**Application for Lawful Development Certificate for an Existing Use or Operation or Activity including those in breach of a planning condition.**

**Development** Application for Certificate of Lawfulness for Existing Use - Storage & distribution with ancillary offices & parking.

**Location** Unit X Rudford Industrial Estate Ford Road Ford

Map Information
 Scale 1:2500
 Date: 09/07/19
 Reference 19043
 Order No: 2133378

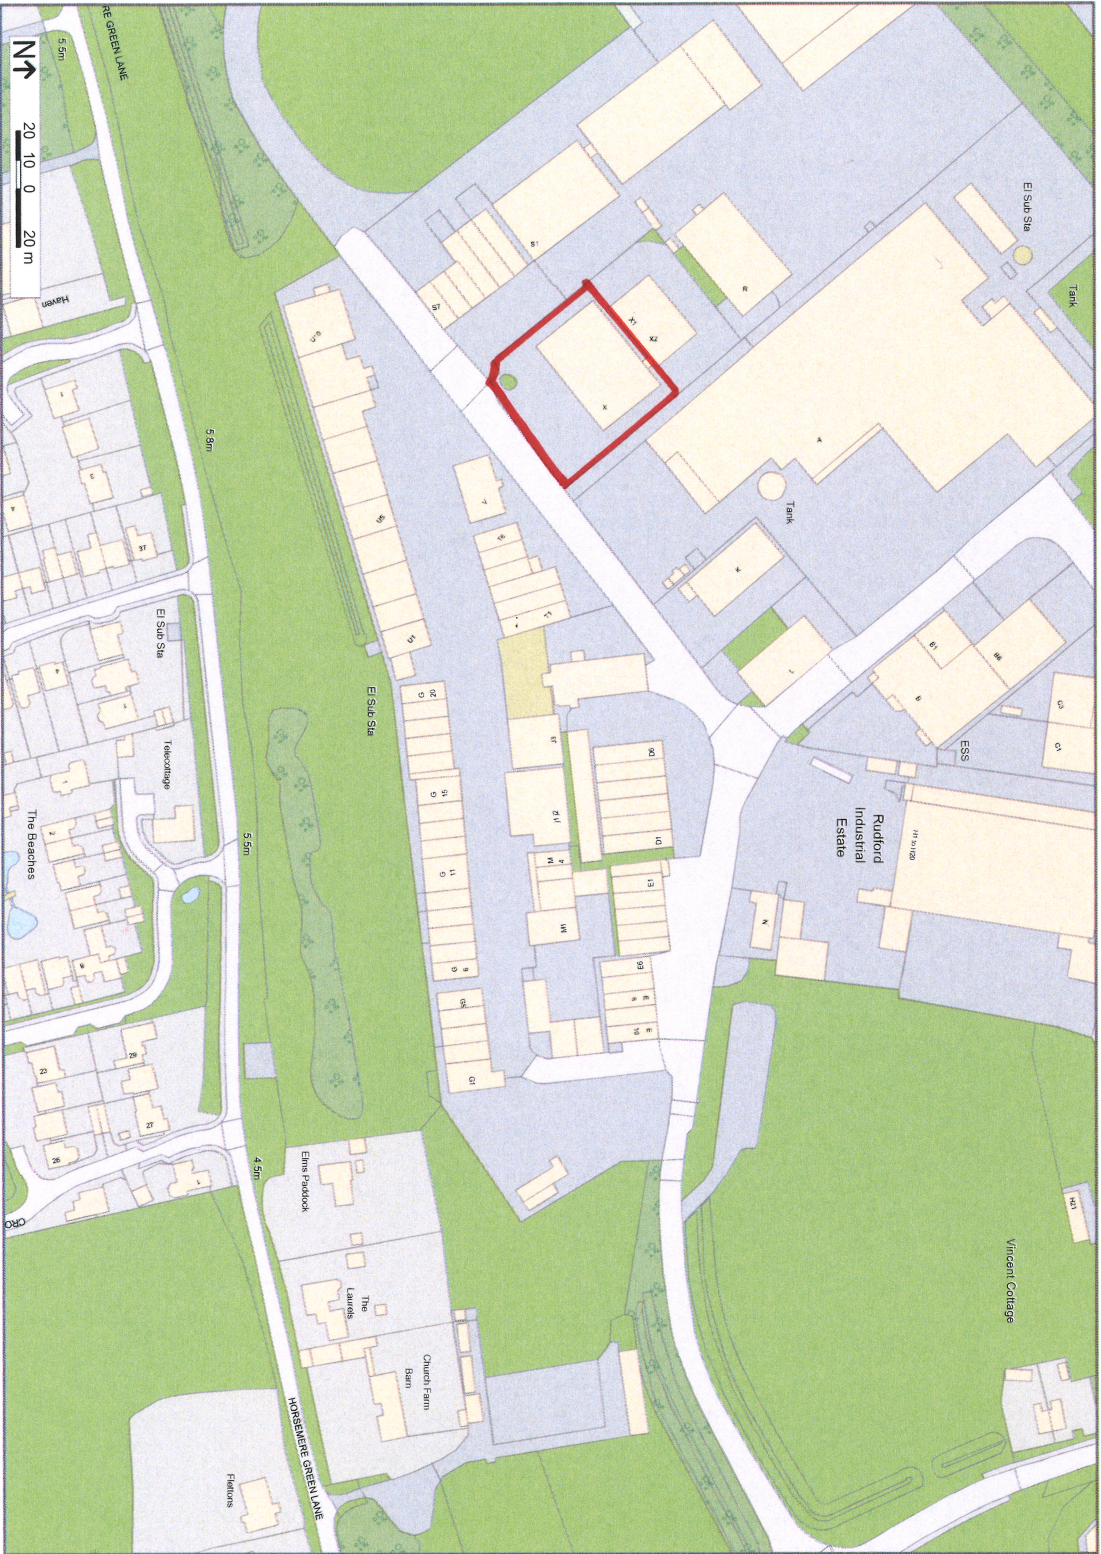
Location Plan

Please submit 1 electronic or 3 paper copies of an amended location plan showing 2 named roads
